**Item No.**                      **Report of the Head of Development Management and Building Control**

**Address:**                      25 DENE ROAD NORTHWOOD

**Development:**                Variation of Condition 2 (Approved Plans) of planning permission ref. 46479/APP/2020/3055 dated 29-01-2021 (and as amended under planning ref: 46479/APP/2021/2039) (Replacement of existing buildings with a 2.5 storey building comprising self-contained flats, parking, landscaping works and widening of vehicular crossover to front) (Revised description approved under non-material amendment application number 46479/APP/2021/1209 dated 12/04/21) to change the approved floor plans and elevations due to the addition of balconies and lower ground floor steps.

**LBH Ref Nos:**                **46479/APP/2023/2507**

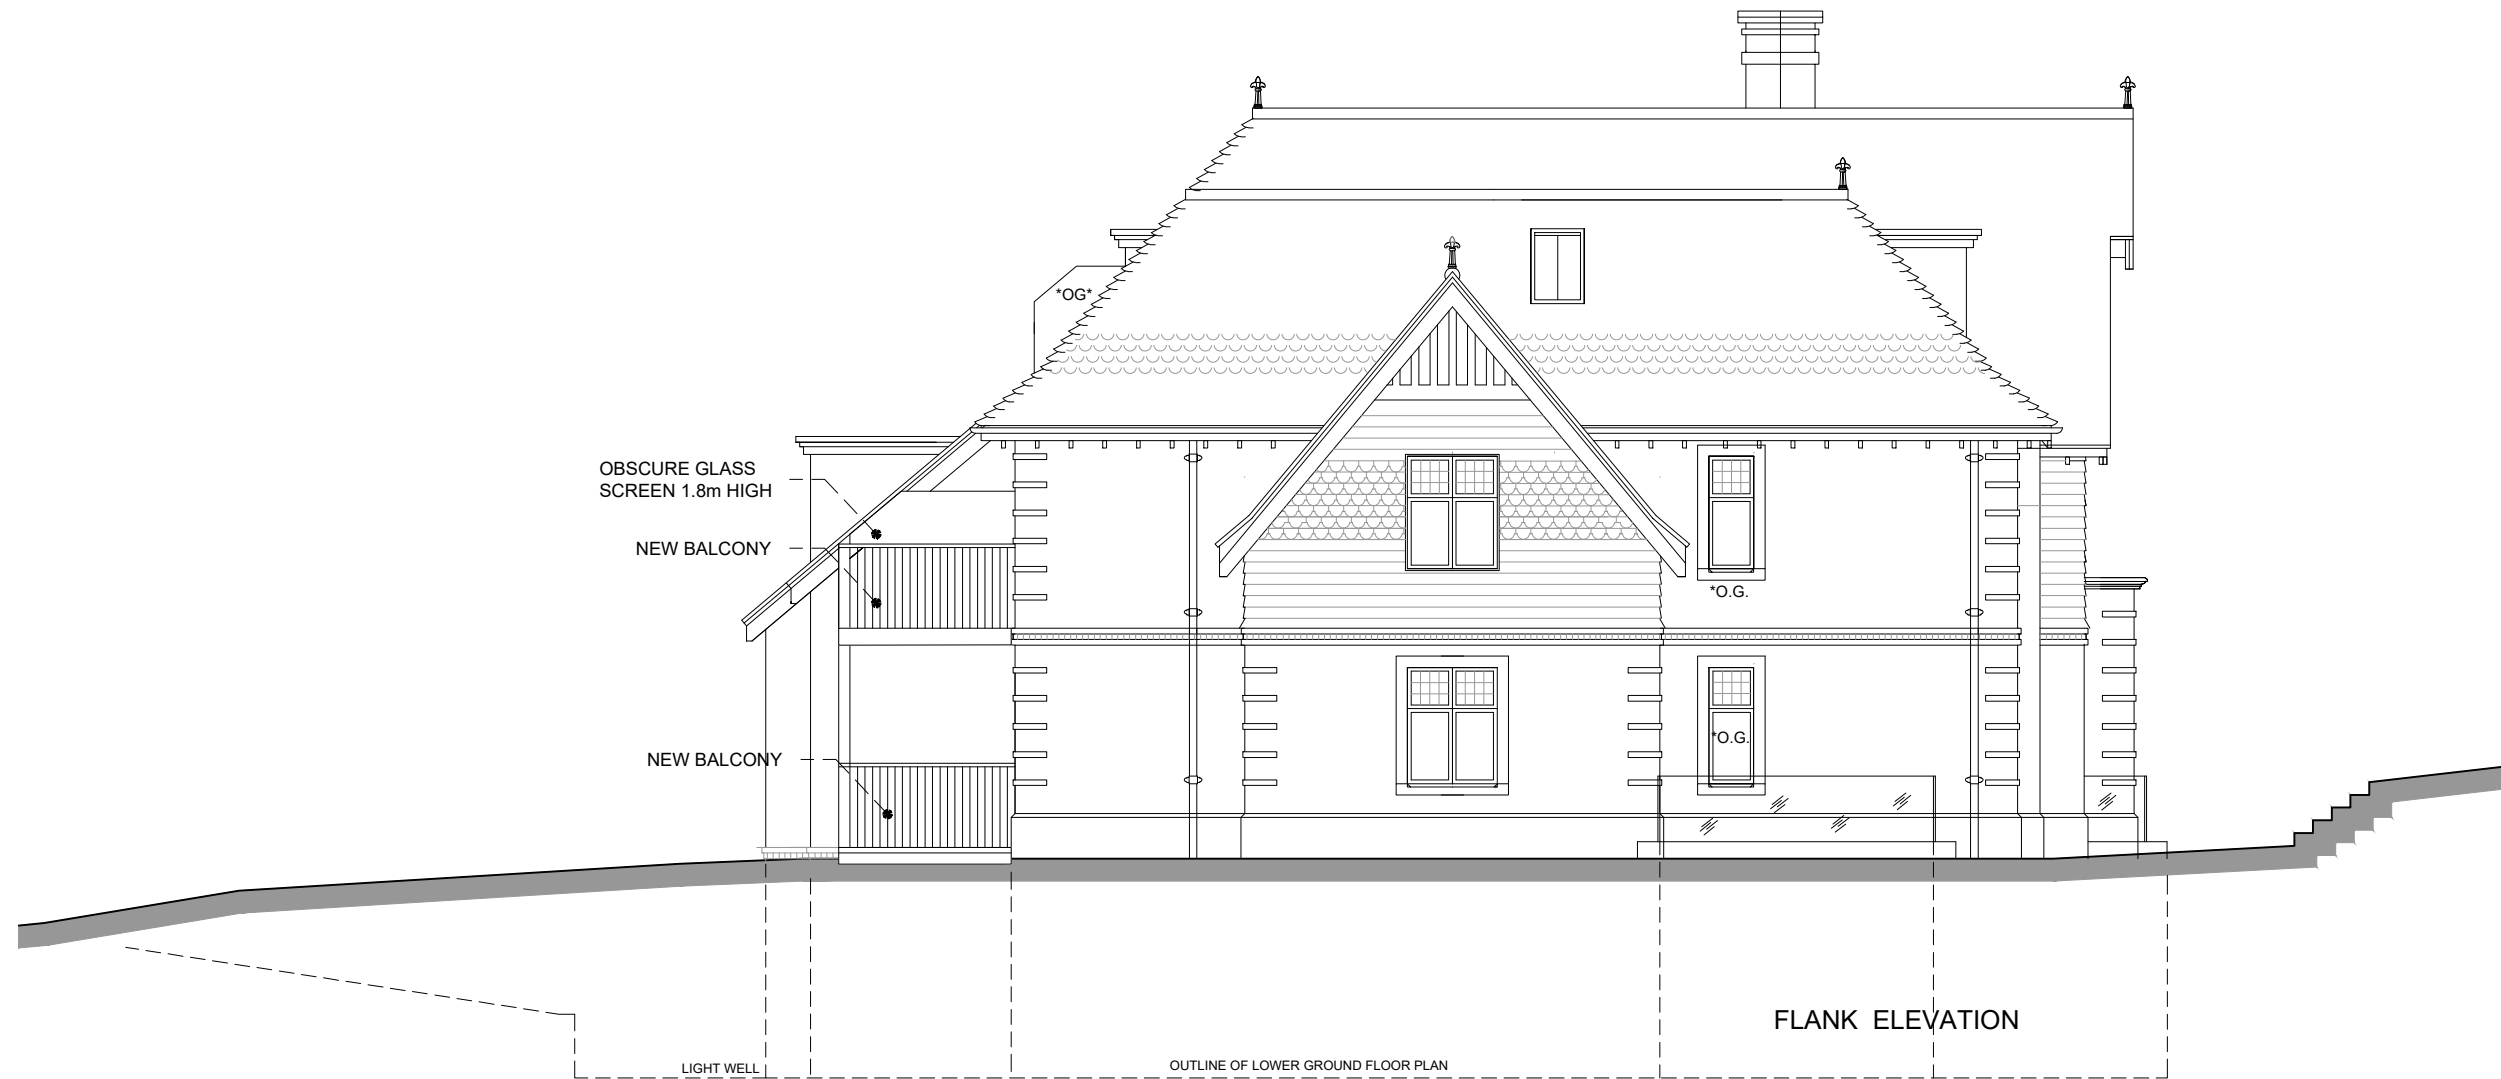
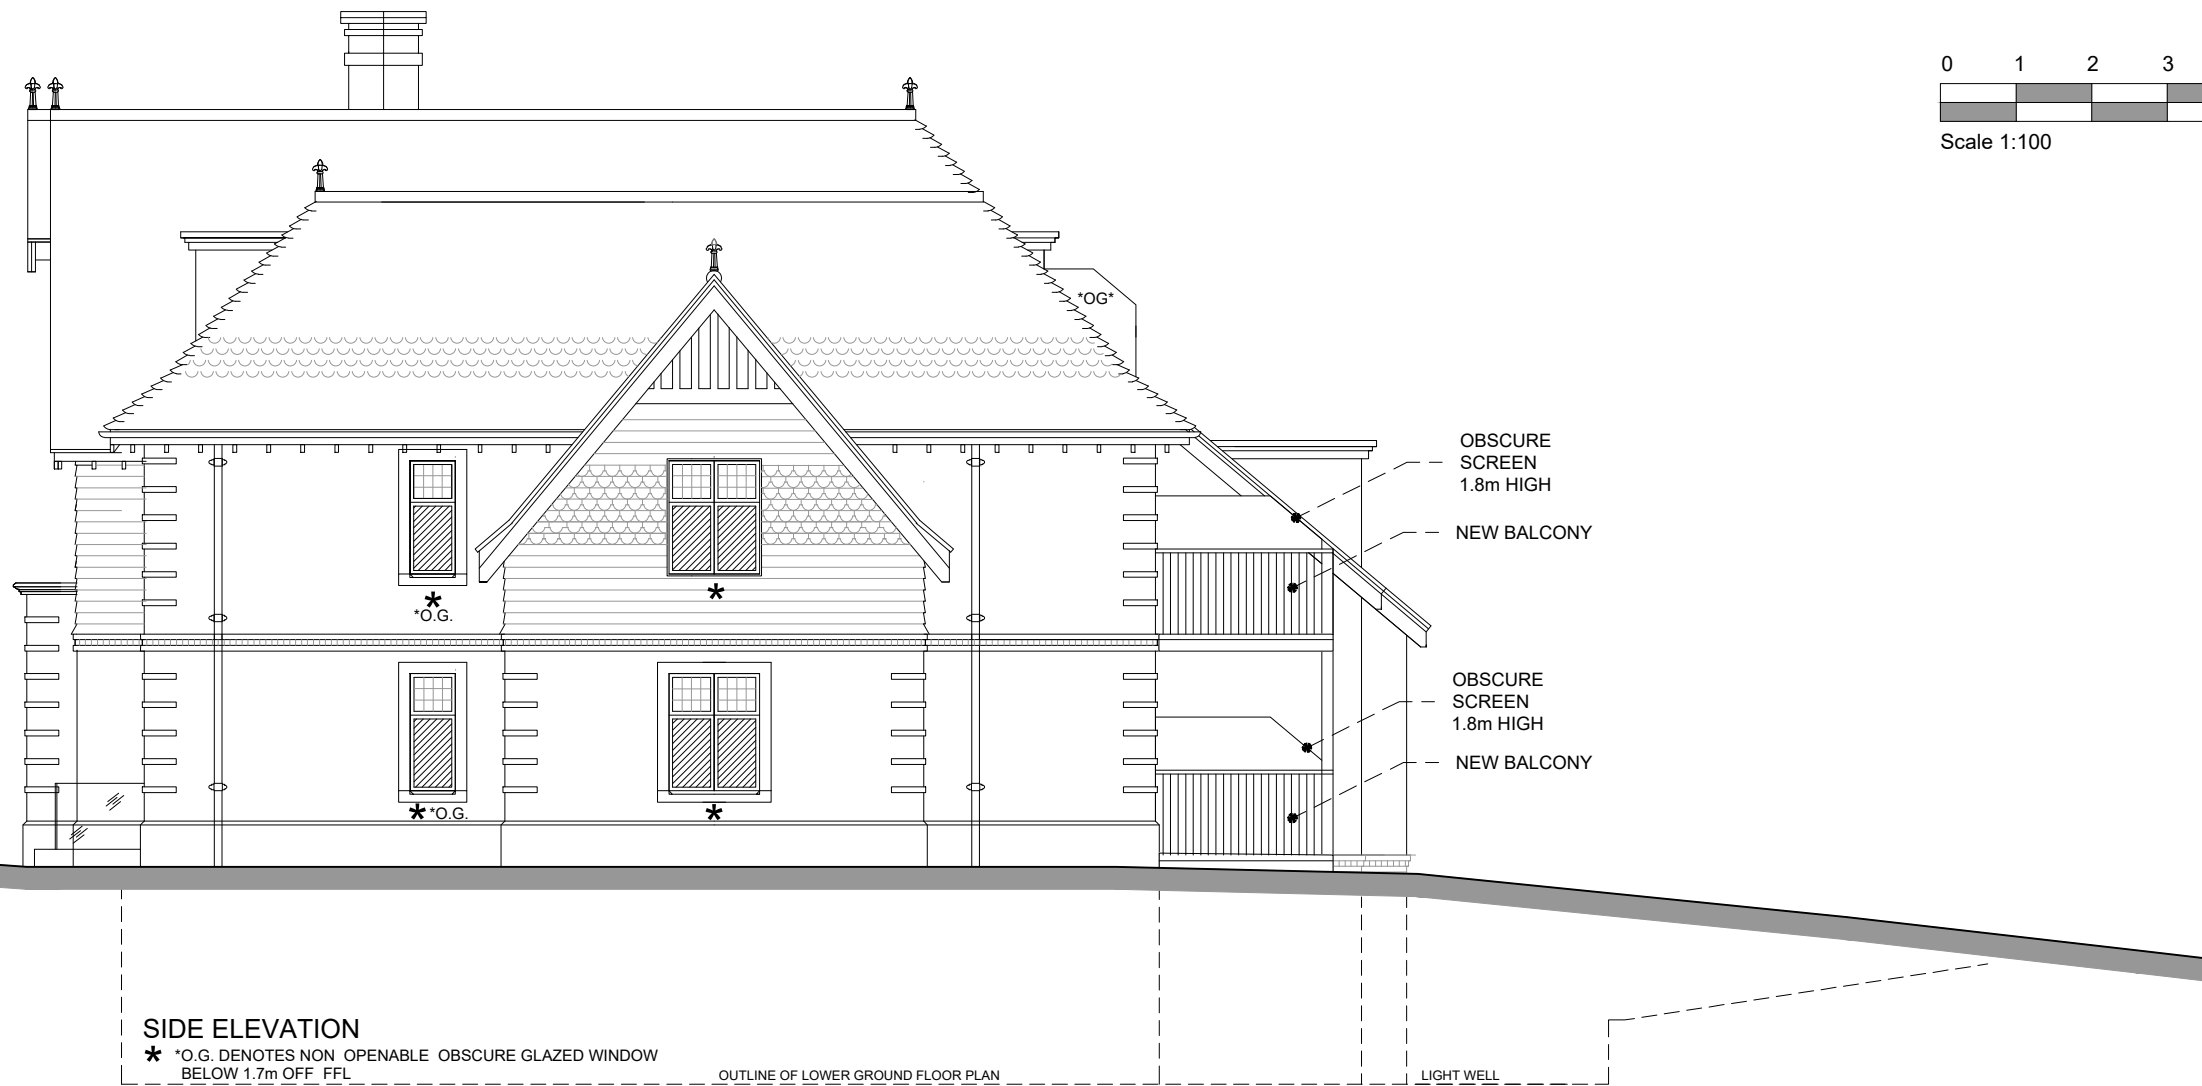
Revisions were sought to address privacy concerns and ensuring the proposed daylight and sunlight of the units are adequate. It is considered that the proposal would not give rise to a material loss of overlooking or privacy for neighbouring occupiers beyond that of the original approved scheme, in accordance with Policy DMHB 11 of the Hillingdon Local Plan: Part 2 - Development Management Policies (2020). In addition, subject to the full landscaping details, it is considered that proposed amendments would not unduly impact on the overall character, appearance or design quality of the development or the wider setting of the ASLC and would provide appropriate levels of parking and amenity space.

Prior to the implementation of minor amendment application ref:46479/APP/2023/2507, details of the balcony privacy screens shall be submitted to the Local Planning Authority for approval. Notwithstanding the approved drawings, the privacy screens shall be 1.8 metres high for its entire length and permanently obscure glazed to at least scale 4 on the Pilkington scale. The approved privacy screen shall be implemented prior to first occupation of the extension and retained for the lifetime of the development.

- Landscaping details would be secured by condition to ensure they are of high quality with good levels of screening.
- The balconies would have 1.8m high privacy glass secured by condition.
- The obscure glazed windows would be secured by condition to ensure they are implemented fully.

**SIDE ELEVATION**  
\* O.G. DENOTES NON OPENABLE OBSCURE GLAZED WINDOW  
BELOW 1.7m OFF FFL

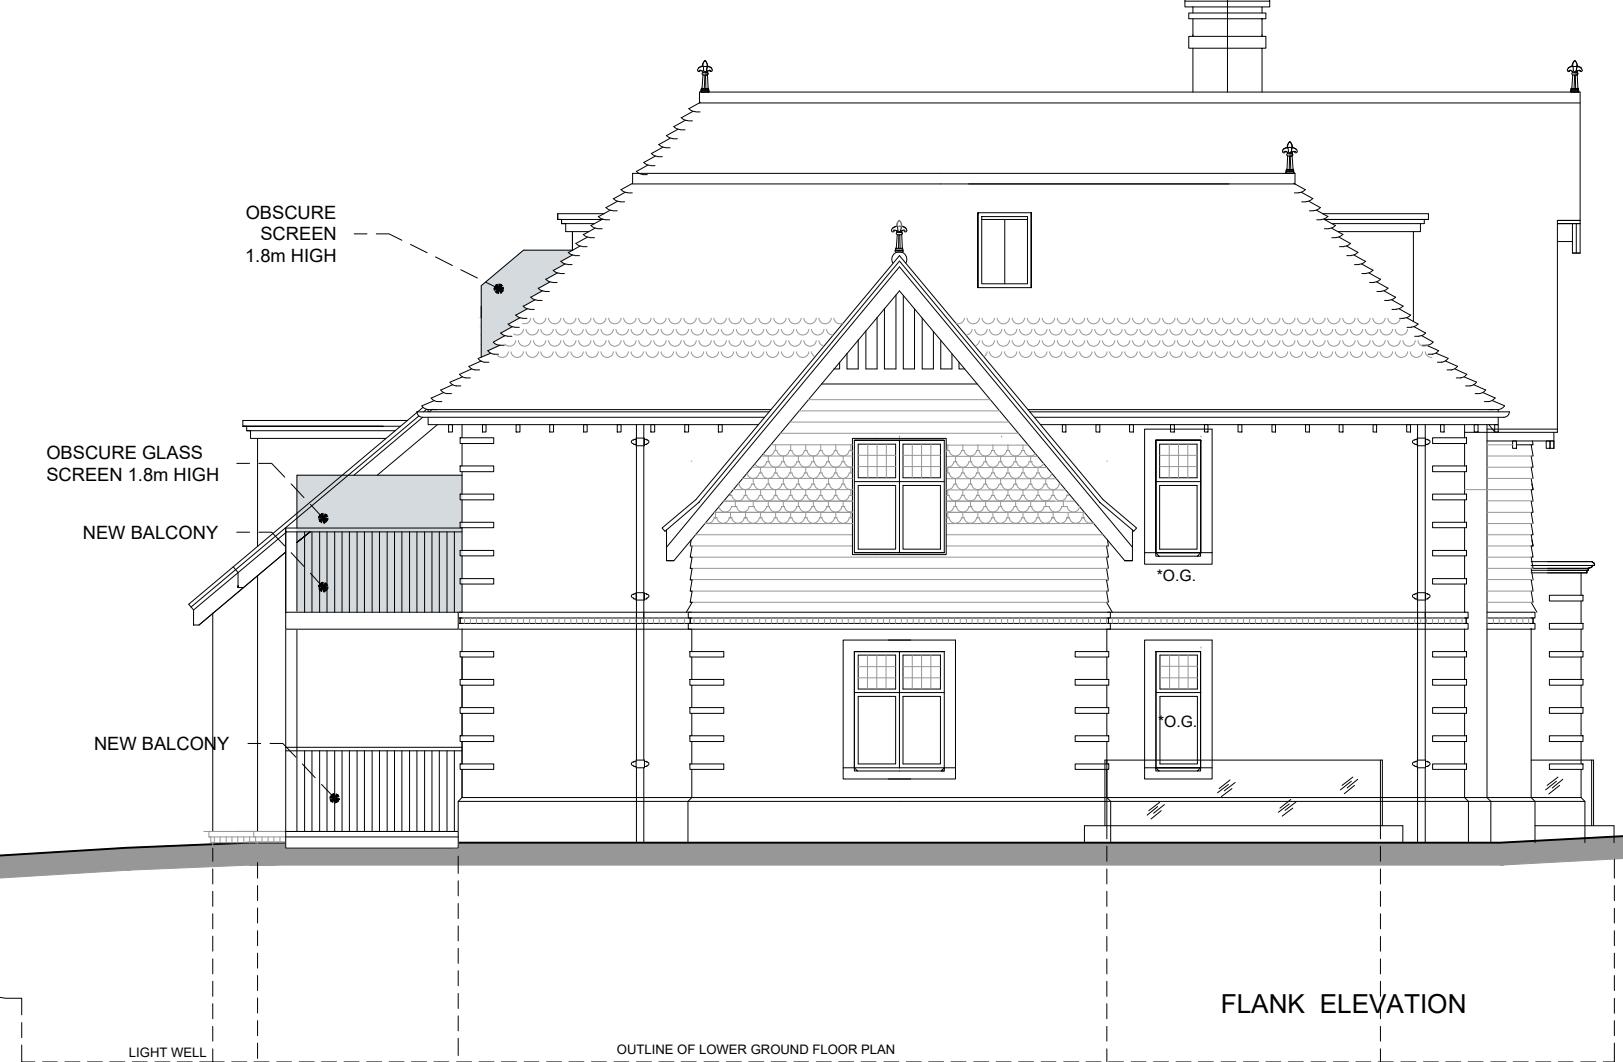
The side elevation plans show only the small windows as being obscured glazing. Presumably it will be conditioned that all side windows are to be obscured glazing as per Condition 4 of application

46479/APP/2020/3055. The same condition should be specifically applied to the balconies even though shown as such on the new plans.

Notwithstanding the approved details, the side elevation windows facing Tormead and 25a Dene Road shall be glazed with permanently obscured glass to at least scale 4 on the Pilkington scale and be non-opening below a height of 1.8 metres taken from internal finished floor level for so long as the development remains in existence.
